Our ref: DOC21/115021-1

Your ref: SSD 15788005

Subject: Jindabyne Education Campus Biodiversity Development Assessment Report

Figure 7-23 Vegetation zones
Source: WSP

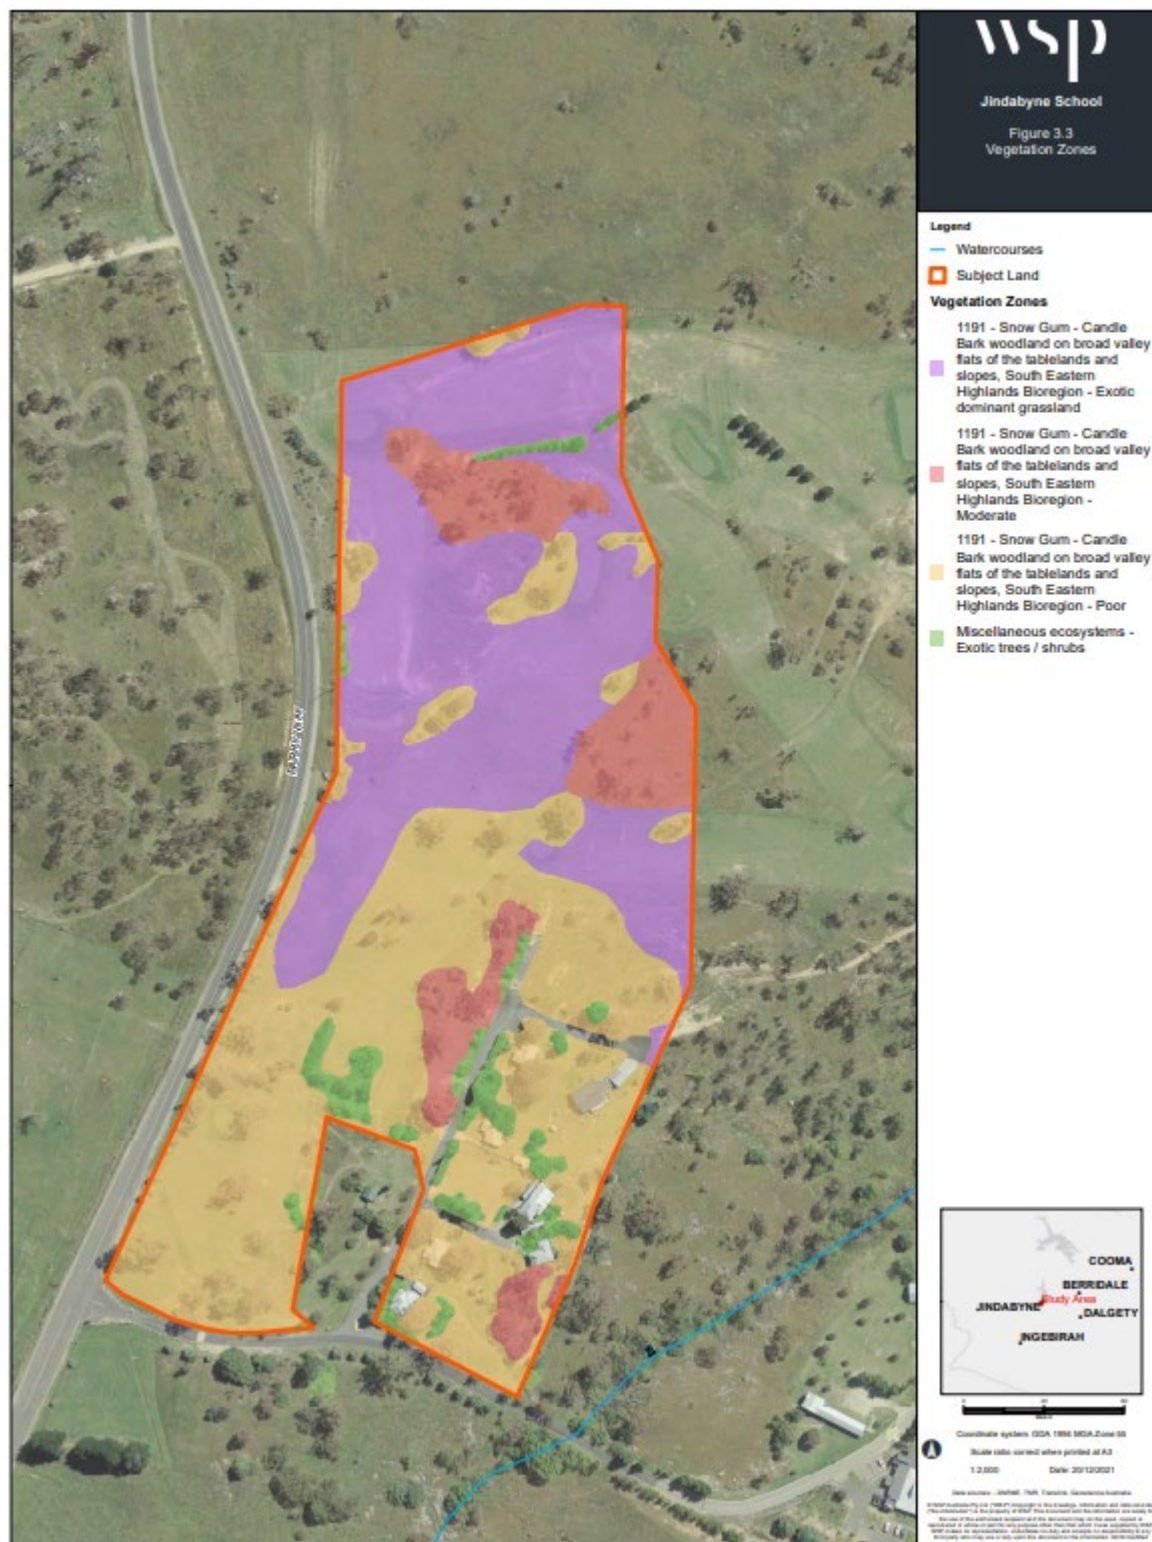
- **Threatened Ecological Communities (TEC)**
 - 8.29 hectares (ha) of impact to the Critically Endangered Ecological Community (CEEC) *Monaro Tableland Cool Temperate Grassy Woodland in the South Eastern Highlands* or Snow Gum Woodland (herein SGW), which is above the threshold Vegetation Integrity (VI) score triggering an offset (VI ≥ 15).

Of additional concern is that the Plant Community Type (PCT) on site is consistent with *Monaro Tableland Cool Temperate Grassy Woodland in the South Eastern Highlands*, or Snow Gum Woodland (herein SGW), which is Critically Endangered Ecological Community (CEEC) and a Serious and Irreversible Impact (SAIL) entity. Therefore –

The BDAR states in section 6.1 *'The current proposal had been designed prior to field surveys for this BDAR. Due to the limited size of the subject land and the scope of the proposal there is limited opportunities for redesign or relocation of the proposal.'*

We consider the final designs of the project should reflect the current constraint of the site in particular the SAI entities that occur on the site. It is important that this development can adequately demonstrate it has avoided the constraints on the site, without a development footprint this is difficult to achieve.

The Assessor found that the impacts to Snow Gum Woodland and Mauve Burr-daisy could be considered serious and irreversible. This requires the decision-maker to take the likely SAIL into consideration and determine if there are any additional and appropriate measures that will minimise the impact if consent is granted. No avoidance of either entity has been undertaken and no measures for minimisation have been proposed by the Assessor. The revised BDAR should provide a development footprint which avoids the SAIL – entities.
